Date: 15 January 2014
Our ref: 109204
Your ref: 3/2013/0854

Planning consultation: Erection of replacement dwelling
Location: Sawley Lodge, Sawley

▲ Photoviewpoint 13 - Existing view: Looking East from public footpath 3-39-FP 7 SD 77482 47106, Bearing 59°

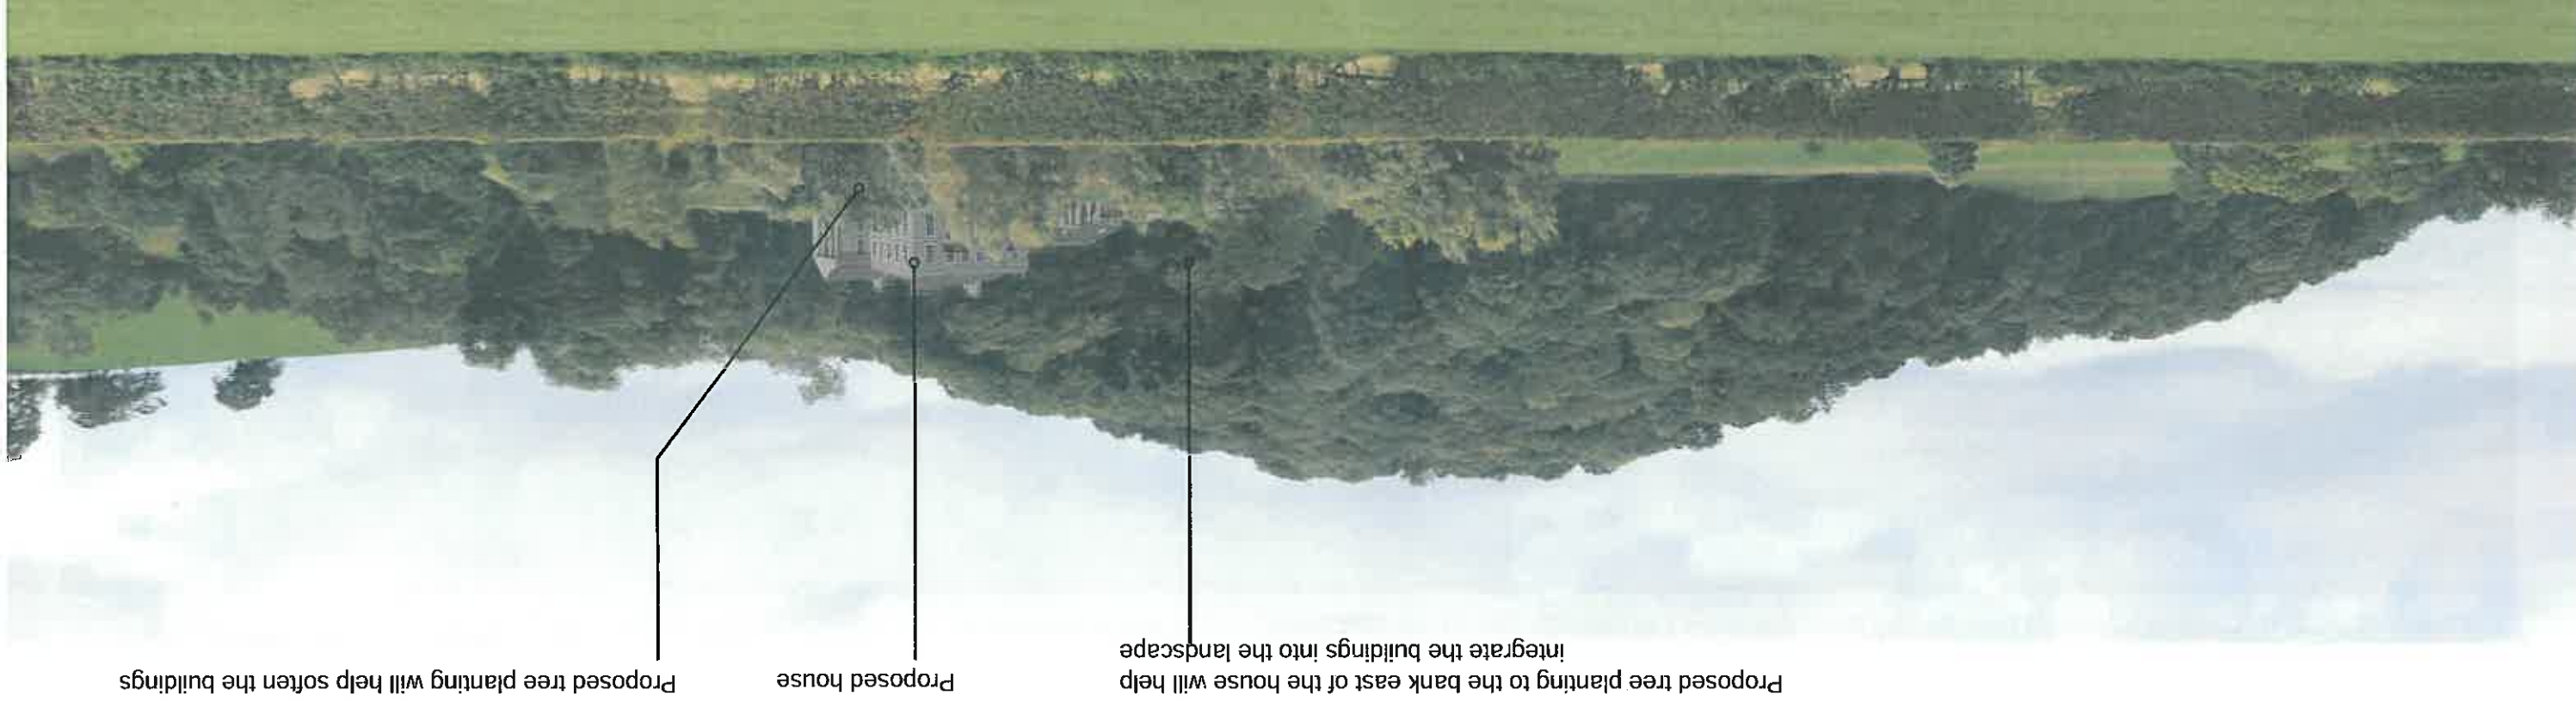
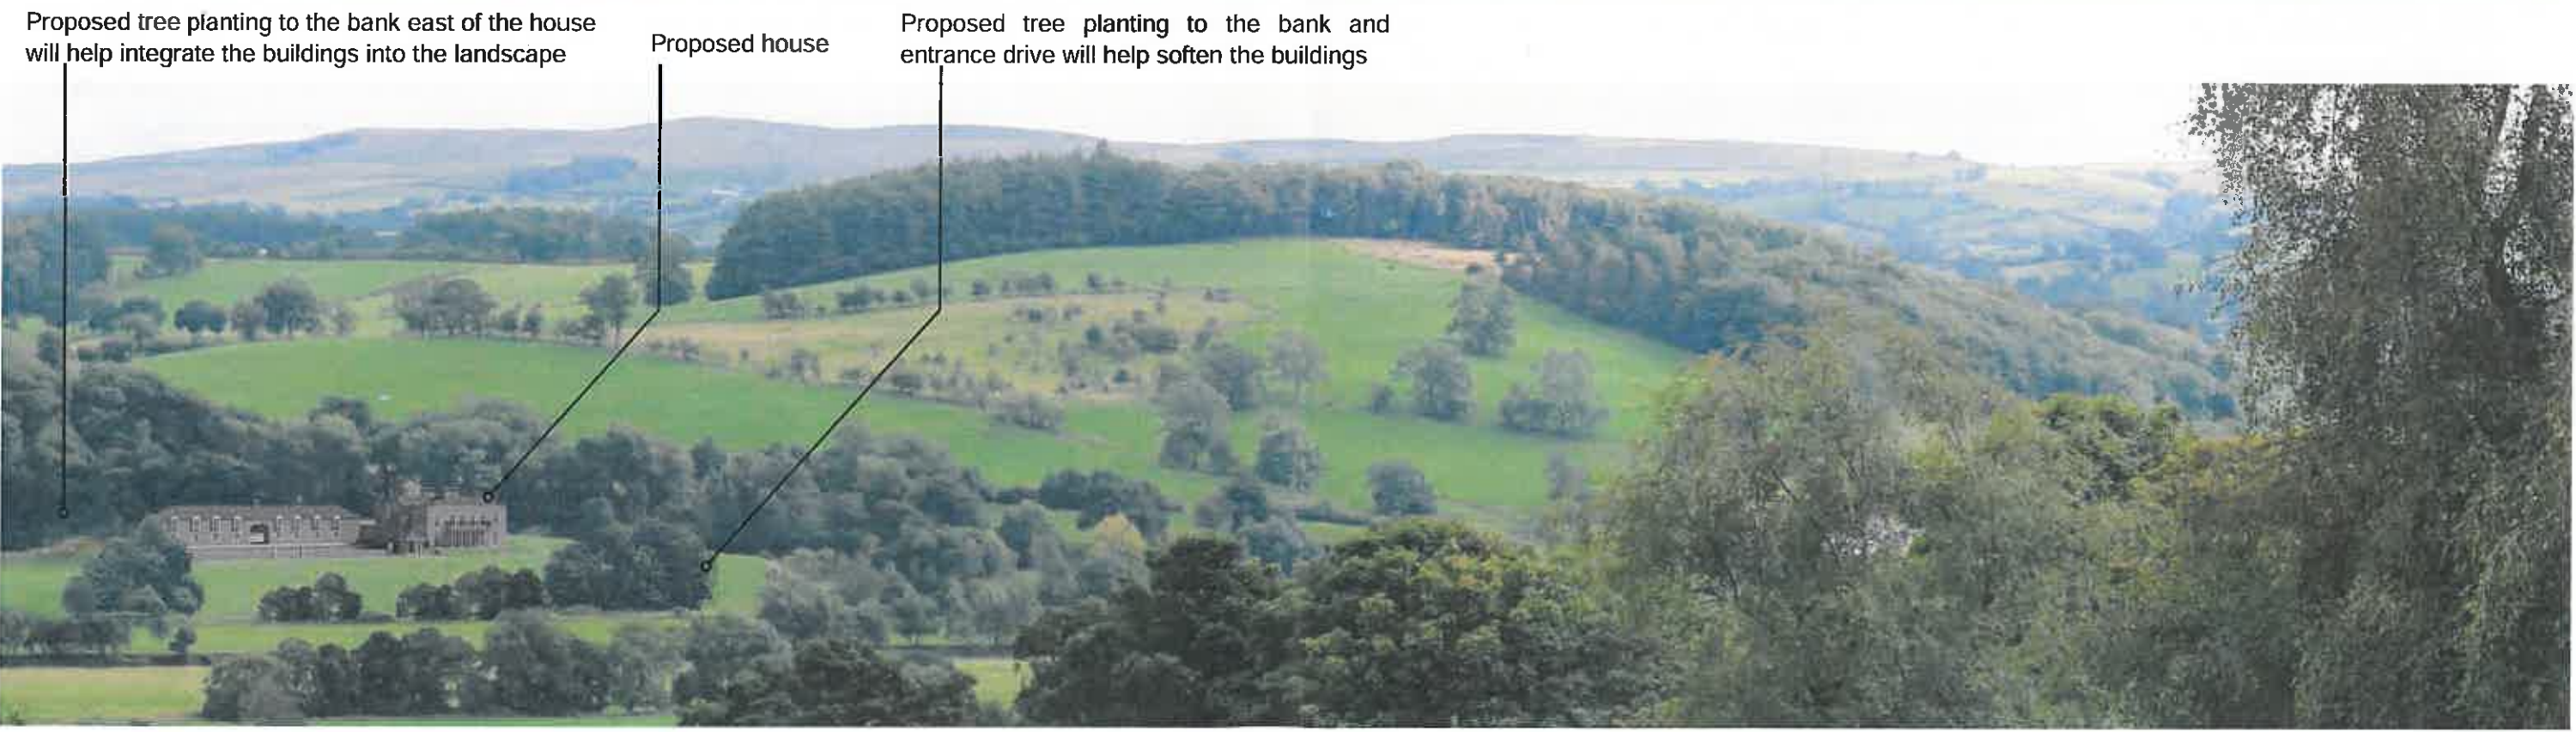
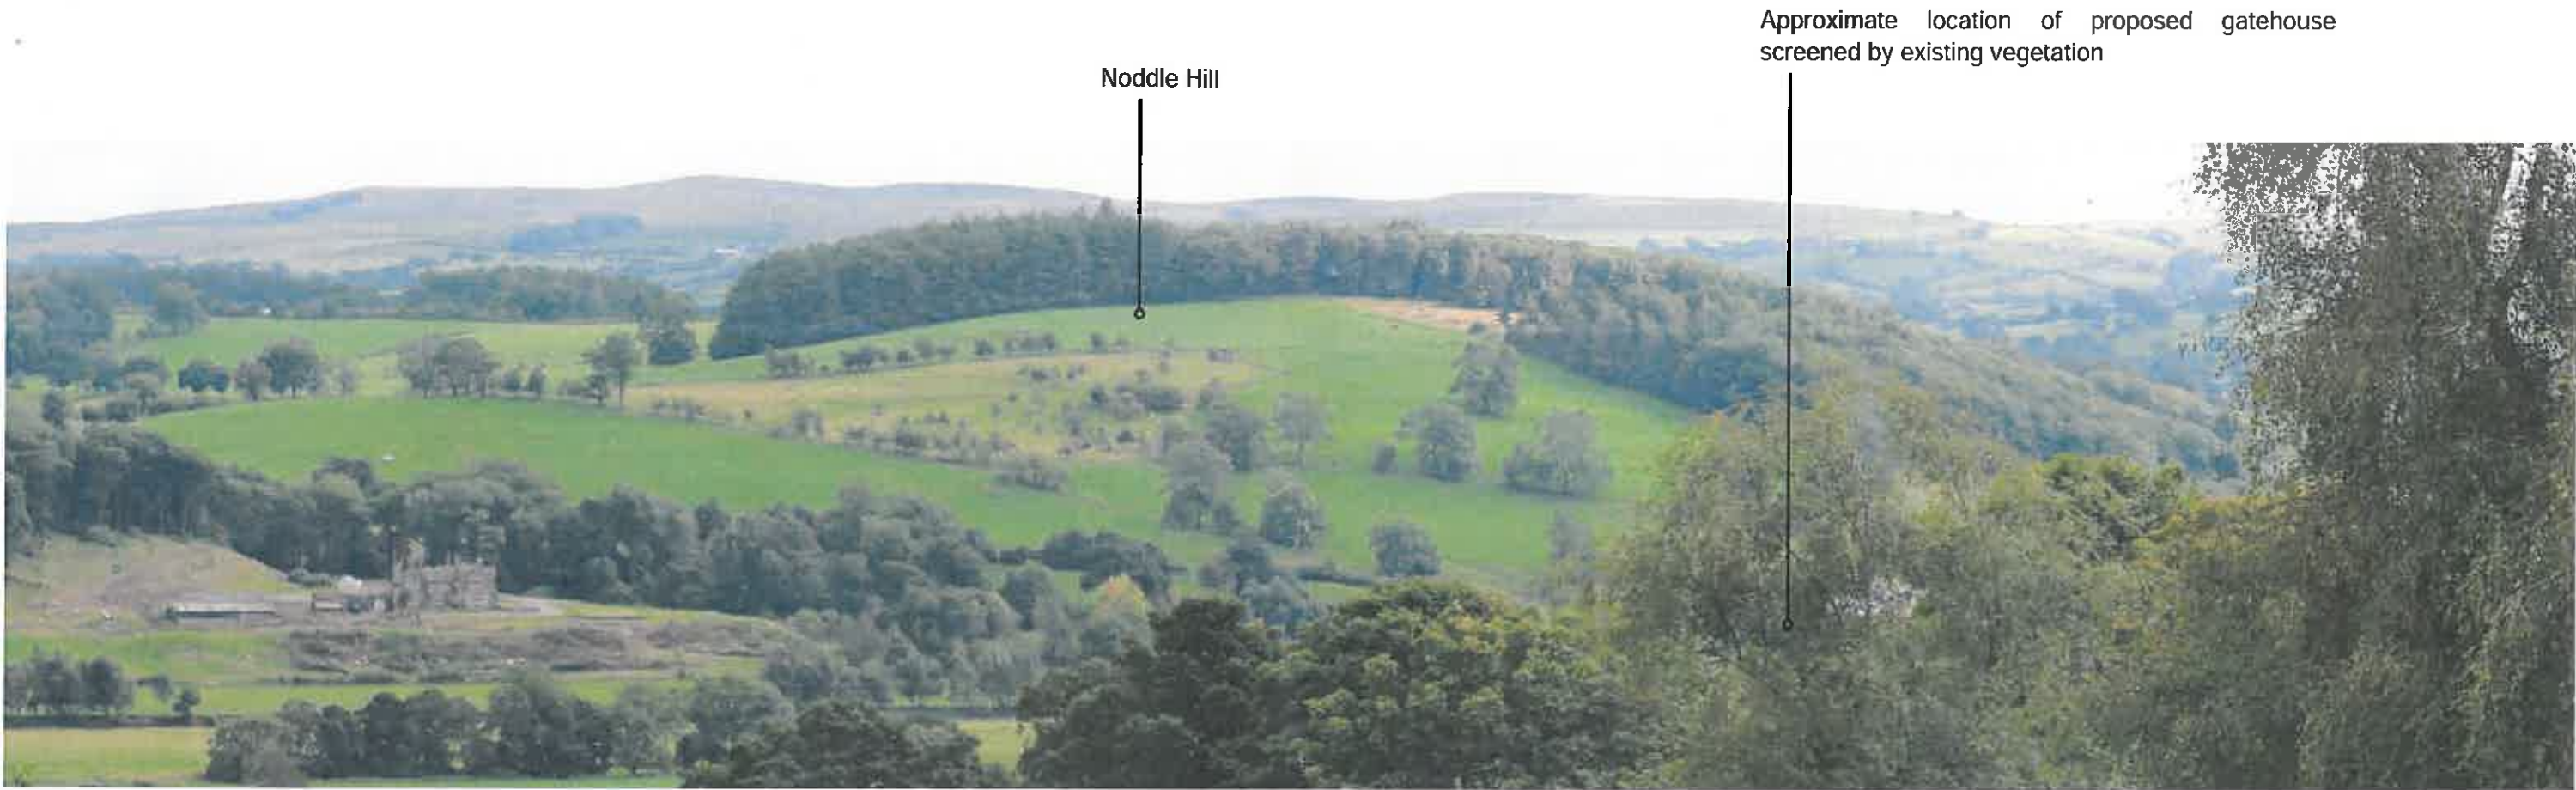
- We are not clear why Figure 12 shows an incomplete image of the 2km study area, rather than centrally locating the proposed site so that the whole of the study area is shown. Are there viewpoints located further east that are not shown on the map?
- **The visual impact assessment methodology has not been described and no information provided on the individual judgements reached for each viewpoints, in order to support the overall conclusion of no significant visual impacts from this proposal.** For example, what sensitivity rating was assigned to each viewpoint, what was the magnitude of change at these locations and how significant was the visual effect considered to be as a result of the proposal being built?
- The photo viewpoints do not illustrate the current view and the future view separately for comparison purposes.
